VACATION OF INTERIOR LOT LINE  
STRUTHERS RANCH SUB FIL. NO. 4A

STRUTHERS-POLARIS RMC  
NEW BUILD

847 STRUTHERS RANCH RD.  
COLORADO SPRINGS, CO 80921  
EL PASO COUNTY, COLORADO

**VACATION OF INTERIOR LOT LINE
STRUTHERS RANCH SUB FIL. NO. 4A**

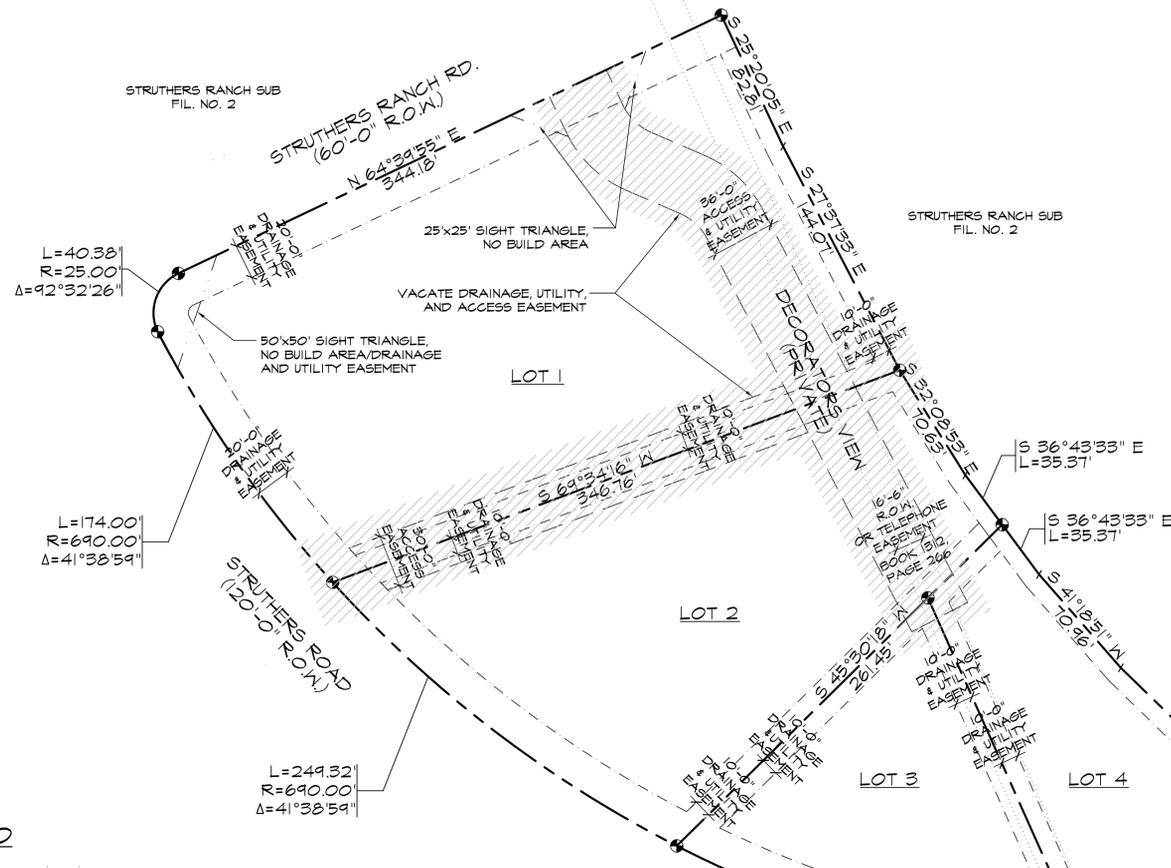
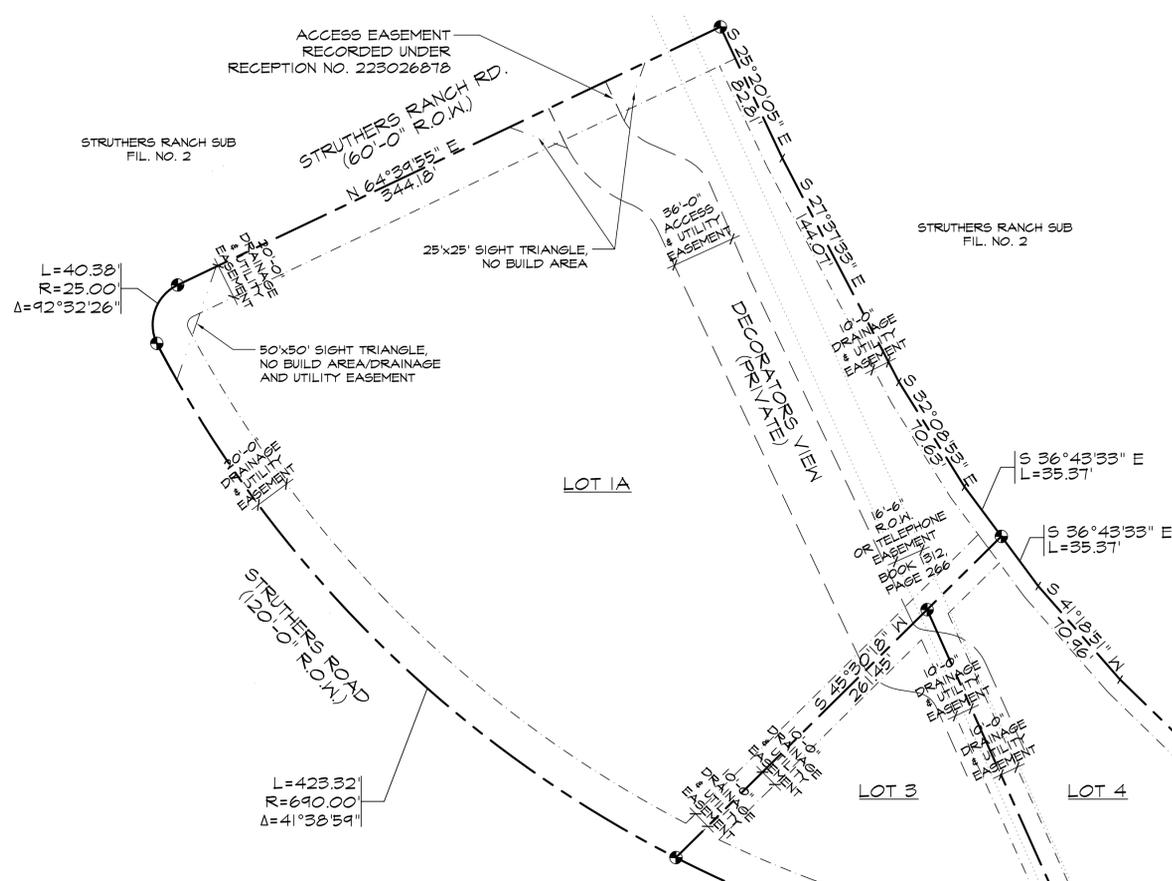
Please add the plat notes below:

The individual lot purchaser(s) shall be responsible for final design, construction, and maintenance of private detention pond/water quality BMP(s) as described in the approved Preliminary/Final Drainage Report for this subdivision. Final design, construction drawings and drainage report updates for the detention pond/water quality BMP(s) serving each lot shall be provided with Site Development Plan submittals. The detention pond/water quality BMP(s) shall be constructed and completed prior to the issuance of any building permits for the subject lots. The subdivision developer is responsible for providing financial assurances as indicated in the Subdivision Improvements Agreement and Estimate of Guaranteed Funds for all detention ponds/water quality BMPs. All detention ponds/water quality BMPs shall be constructed prior to the release of said financial assurances.

Individual lot purchasers shall enter into a Private Detention Basin / Stormwater Quality BMP Maintenance Agreement and Easement ("Agreement") prior to the issuance of any building permits for the subject lots. In the case that the developer constructs the detention pond(s), the developer shall enter into an Agreement for each pond constructed.

Unless otherwise indicated, all side, front, and rear lot lines are hereby platted on either side with a 10 foot public utility and drainage easement unless otherwise indicated. All exterior subdivision boundaries are hereby platted with a 20 foot public utility and drainage easement. The sole responsibility for maintenance of these easements is hereby vested with the individual property owners.

There shall be no direct lot access to Struthers Road.

The private roads as shown on this plat will not be maintained by El Paso County until and unless the streets are constructed in conformance with El Paso County standards in effect at the date of the request for dedication and maintenance.

This property is located within a designated FEMA Floodplain as determined by the Flood Insurance Rate Map, Community Map Number \_\_\_\_\_, effective date \_\_\_\_ (modification when LOMR has been approved) and as amended by the FEMA approved Letter of Map Revision (LOMR) case number \_\_\_\_\_ dated \_\_\_\_\_. No structures are permitted within the designated Floodplain areas. (Modification of this note may be allowed if the intent is to allow construction of structures through the Floodplain Development Permit Process- example: retaining wall in excess of 4 feet is a structure)

No grading or other site work is permitted on any lot prior to approval of a plot plan for the lot.

All structural foundations shall be located and designed by a professional engineer, currently registered in the state of Colorado.

No driveway shall be established unless an access permit has been granted by El Paso County.

Mailboxes shall be installed in accordance with all El Paso County and United States Postal Service regulations.

A twenty-five foot (25') by twenty-five foot (25') sight triangle no-build area exists for all corner lots except as noted. No obstructions greater than eighteen inches (18") are allowed in this area.

The subdividers(s) agree on behalf of him/herself and any developer of builder successors and assignees that subdivider and/or said successors and assigns shall be required to pay traffic impact fees in accordance with the El Paso County Road Impact Fee Program (Resolution No. 19-471), or any amendments thereto, at or prior to the time of building permit submittals. The fee obligation, if not paid at final plat recording, shall be documents on all sales documents and in plat notes to ensure that a title search would find the fee obligation before sale of the property.

Add "PCD File No. V-22-007"
